Department of Transportation

August 28, 2023

RE: Outlook at Powers - SE Quadrant of SH21/Grinnell

Powers & Grinnell
Bypass Line
Profile Report
Engineering Profile - Profile - 1 (Bypass Storm.stsw)
Active Scenario: 100 YR

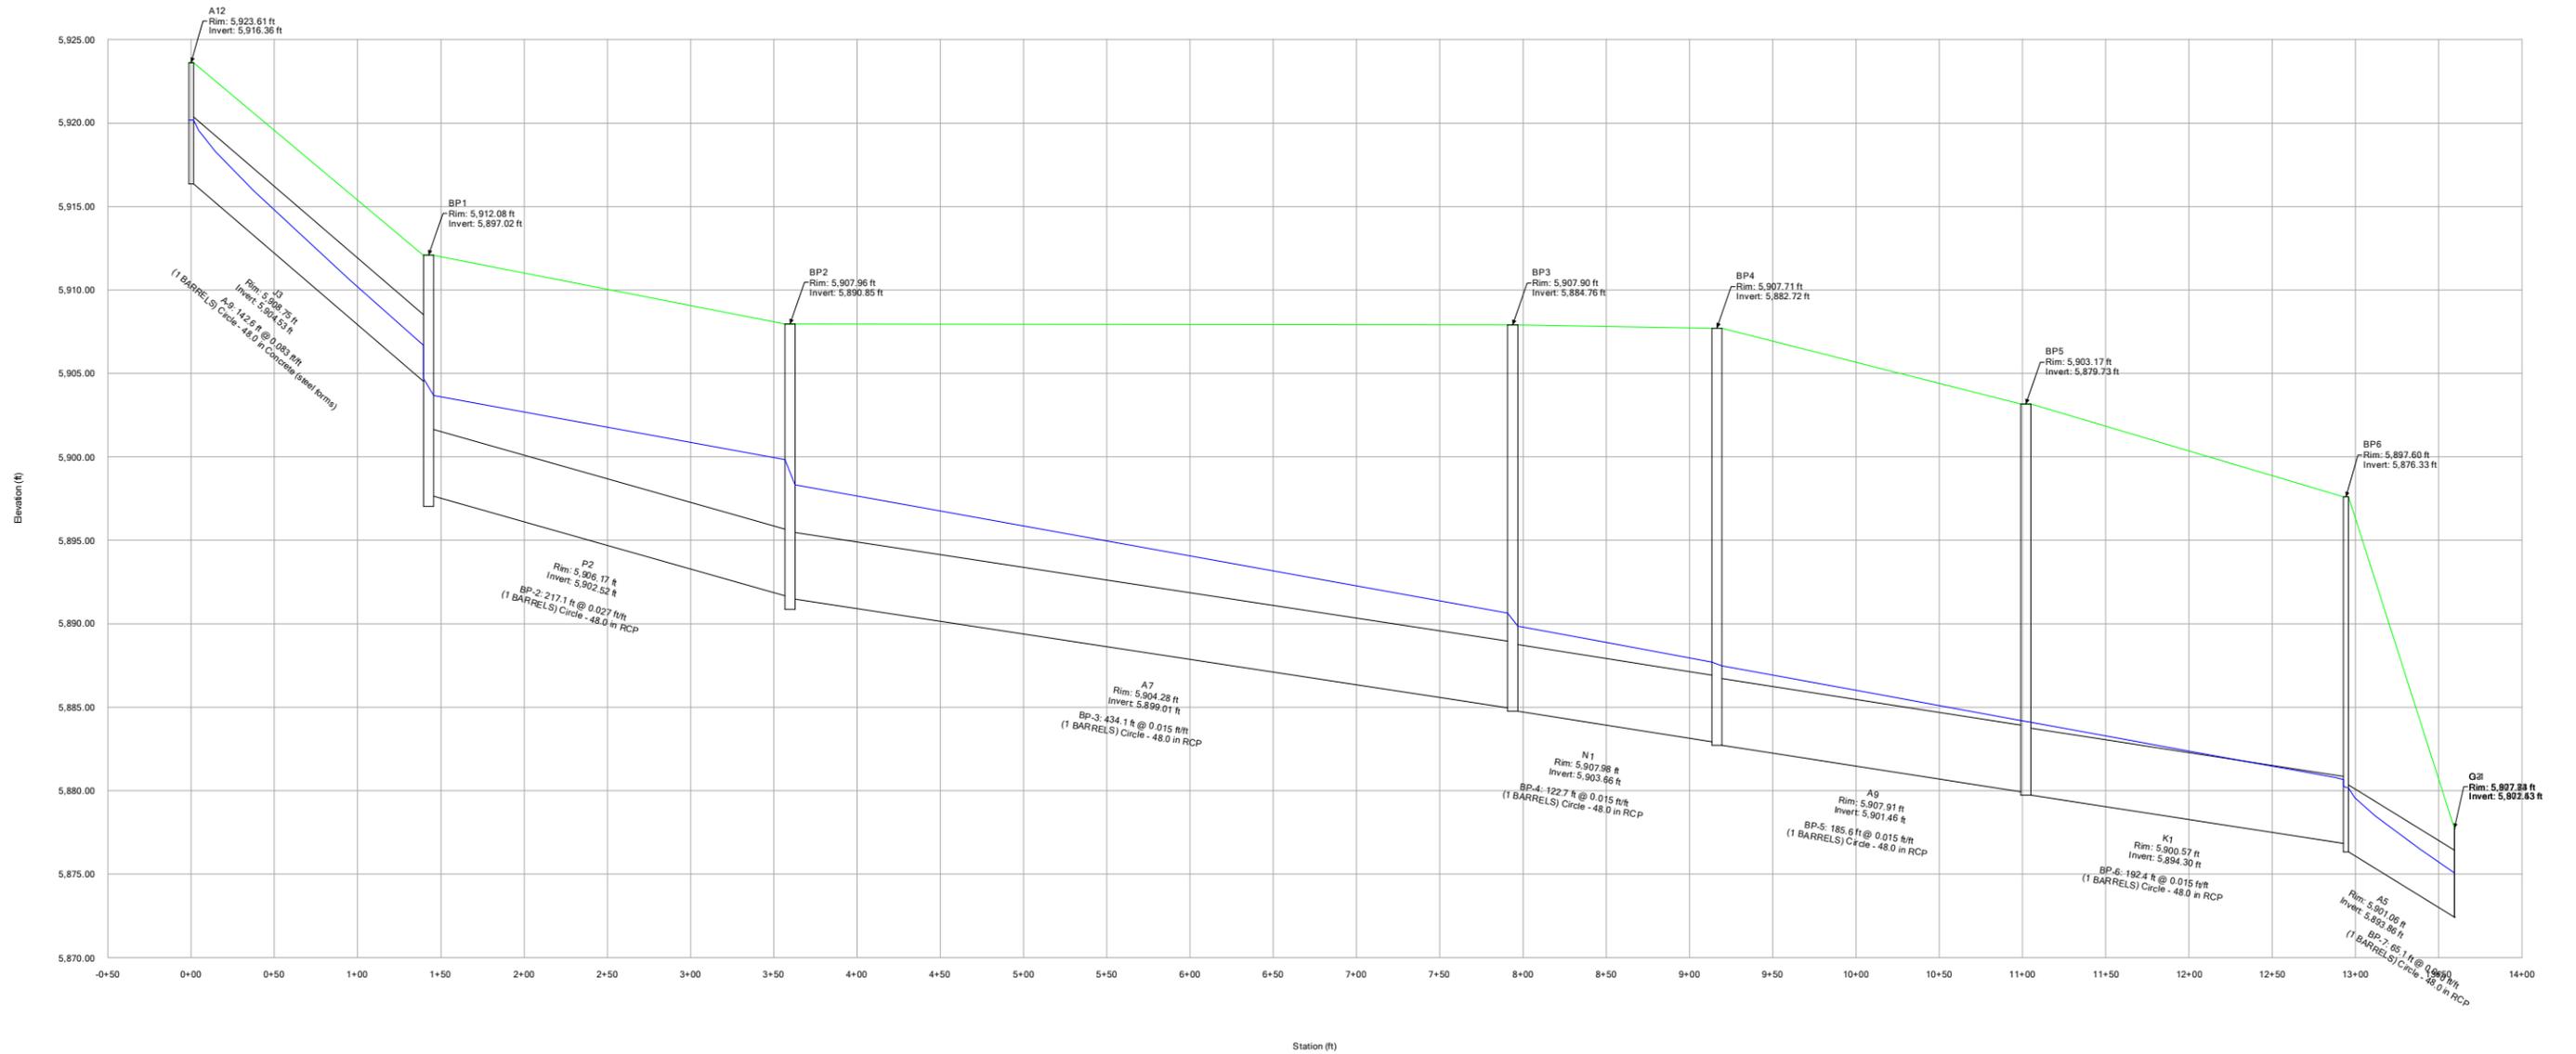
- Plans Sheet 8 - The proposed storm line shows a 48" RCP connecting to the existing system under Powers. The existing storm is dual 8x3 CBCs. Confirm there will be no backups upstream of Powers as a result of making a smaller connection downstream. Pipe upstream of BP1 is not shown in the profile.
